OFFICIAL NOTIFICATION OF DECISION

Project #PR-2020-003357
Application#
SD-2020-00040 – PRELIMINARY/FINAL PLAT

All or a portion of **LOTS 6-A-1, 6-A-2, 6-A-3 and 6-A-4, JEFFERSON COMMONS II**, zoned NR-BP, located at **5411 JEFFERSON BLVD NE between SINGER BLVD NE and OFFICE BLVD NE**, containing approximately 17.0507 acre(s). (F-17)

CORRECTION Plat of
Lots 6-A-1, 6-A-2, 6-A-3 and 6-A-4
Jefferson Commons II
 Elena Gallegos Grant Projected
 Section 35, Township 11 North, Range 3 East, N.M.P.M.
 Albuquerque, Bernalillo County, New Mexico
 February 2020

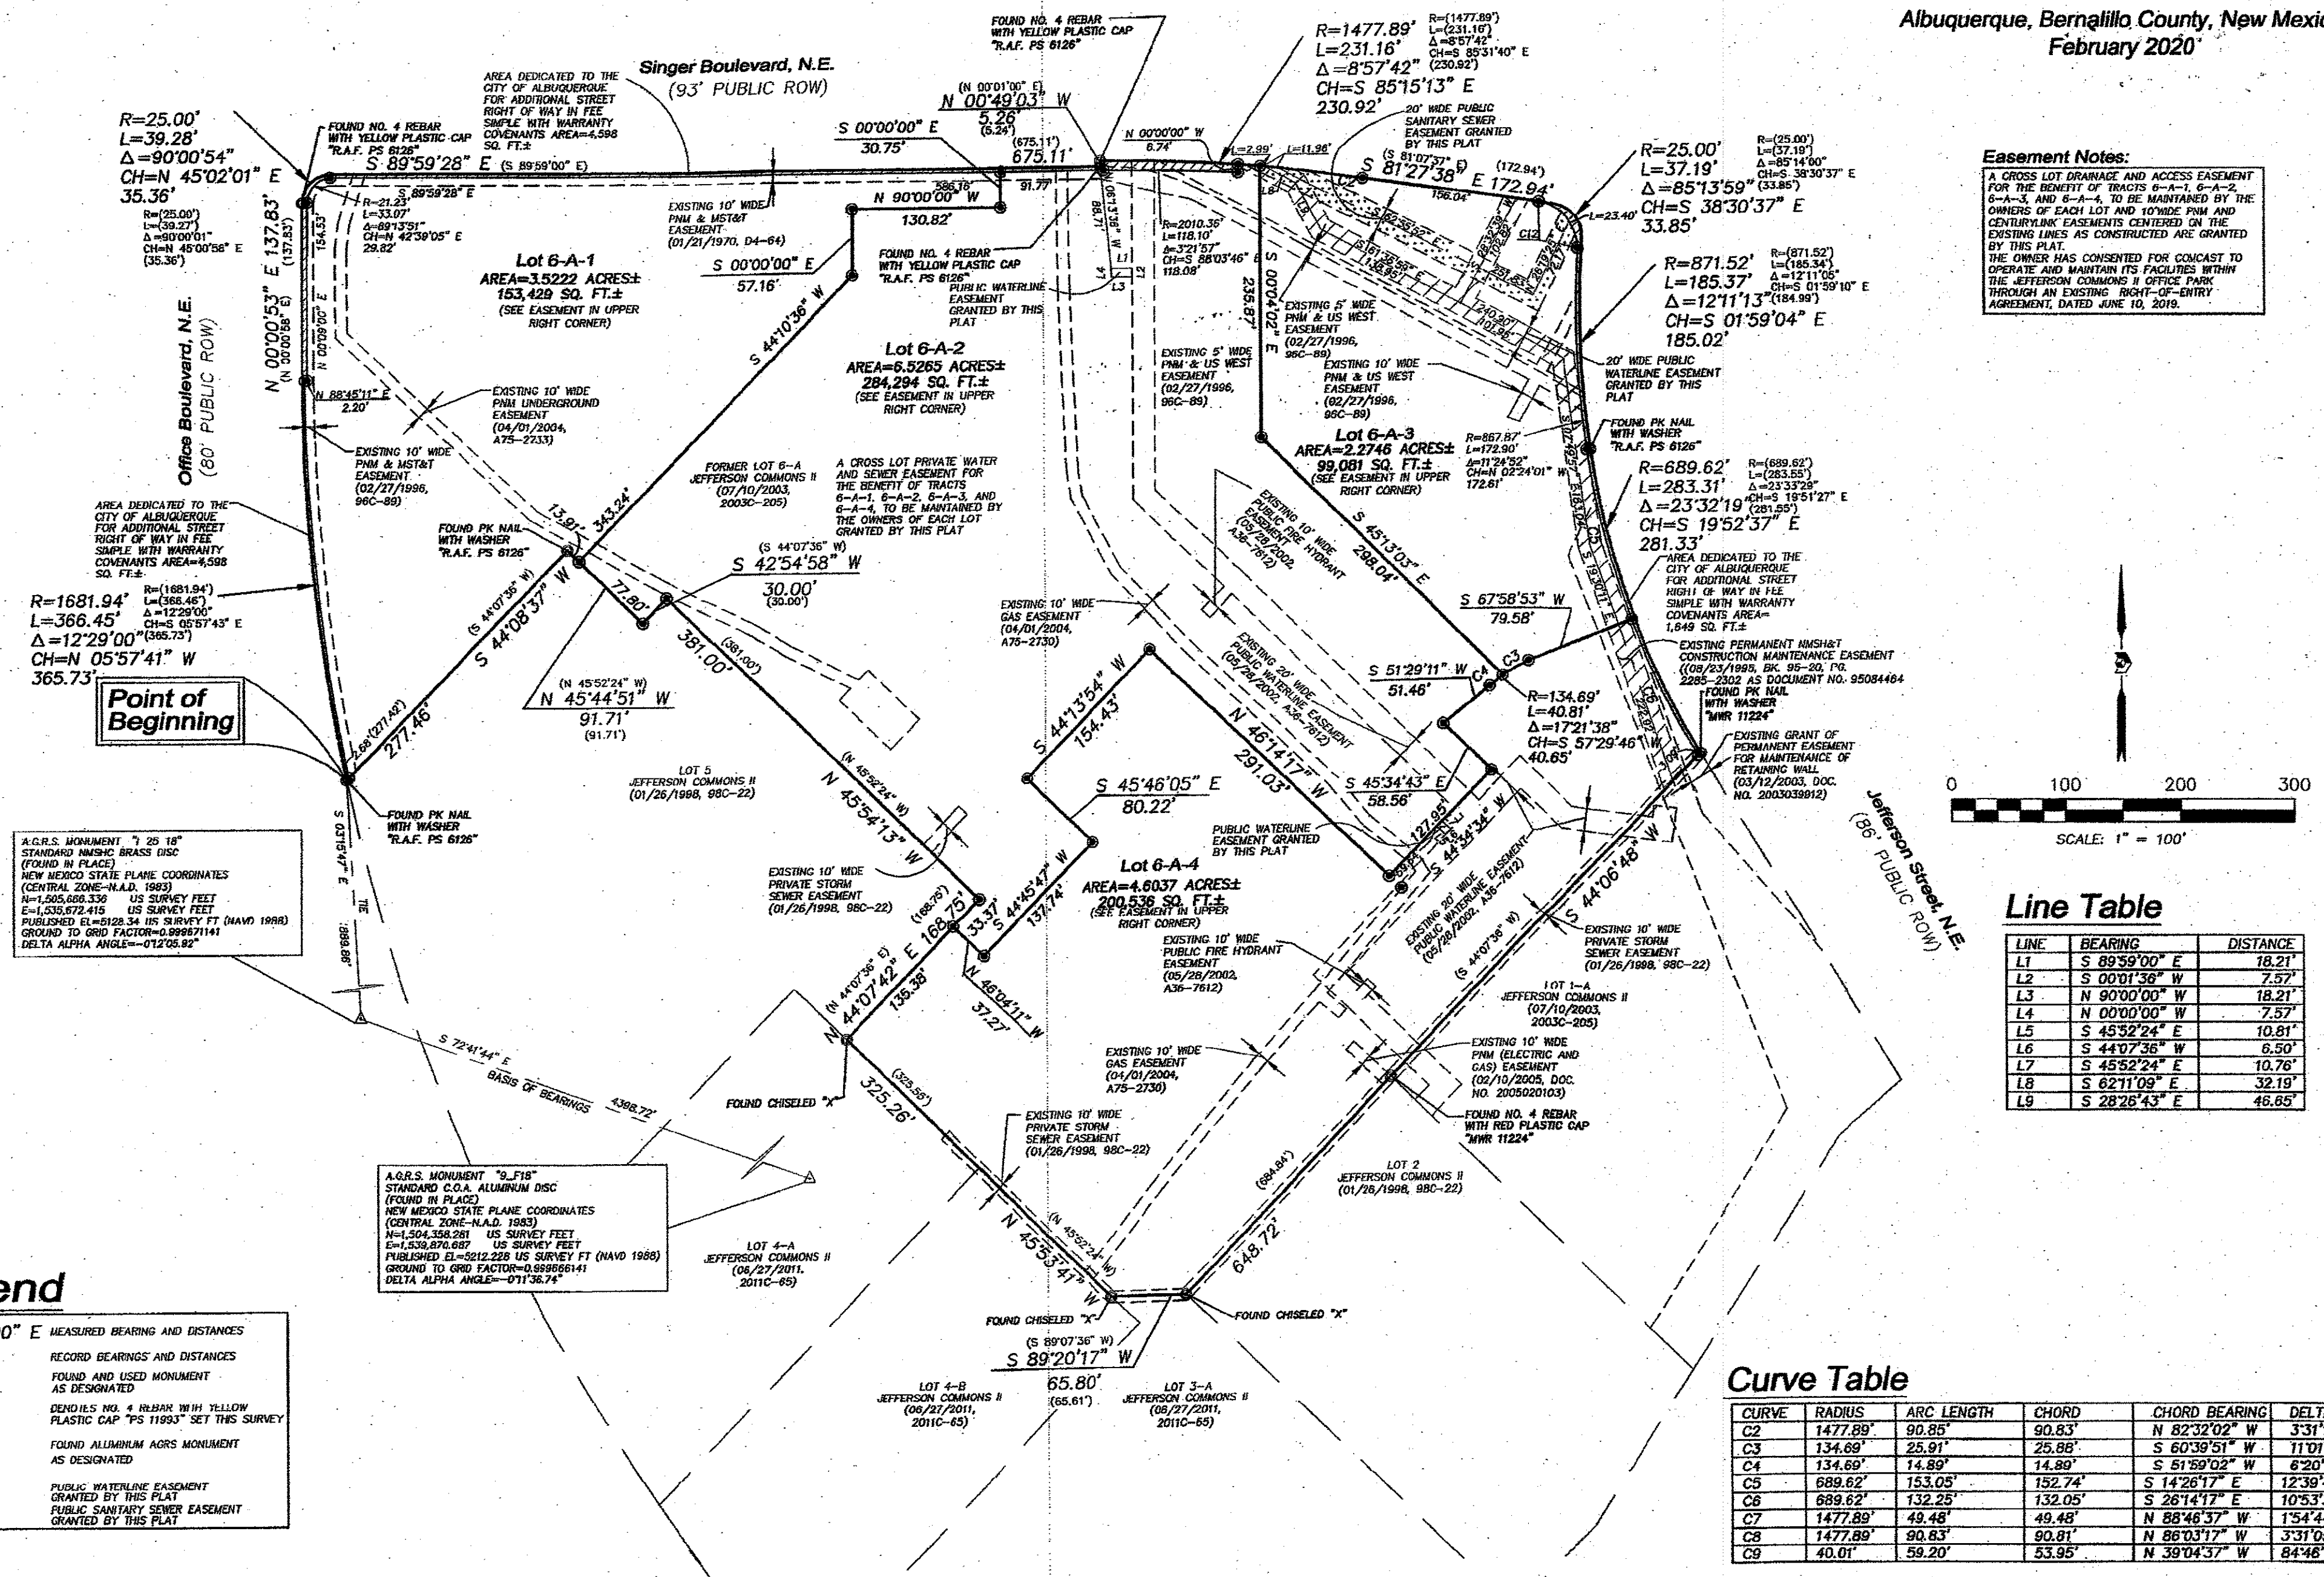
1. Final sign off is delegated to the ABCWUA to confirm the depiction of the existing waterline and sanitary sewer easements that are adjacent to the site and are along the southeast property line within existing Lot 3-A, Lot 2, and Lot 1-A, confirm the labeling of the existing public waterline easement within proposed Lot 6-A-4, and confirm the inclusion of a hatching legend for the proposed easements being granted.
2. Final sign off is delegated to Planning for utility signatures, an IIA, and the DXF file.
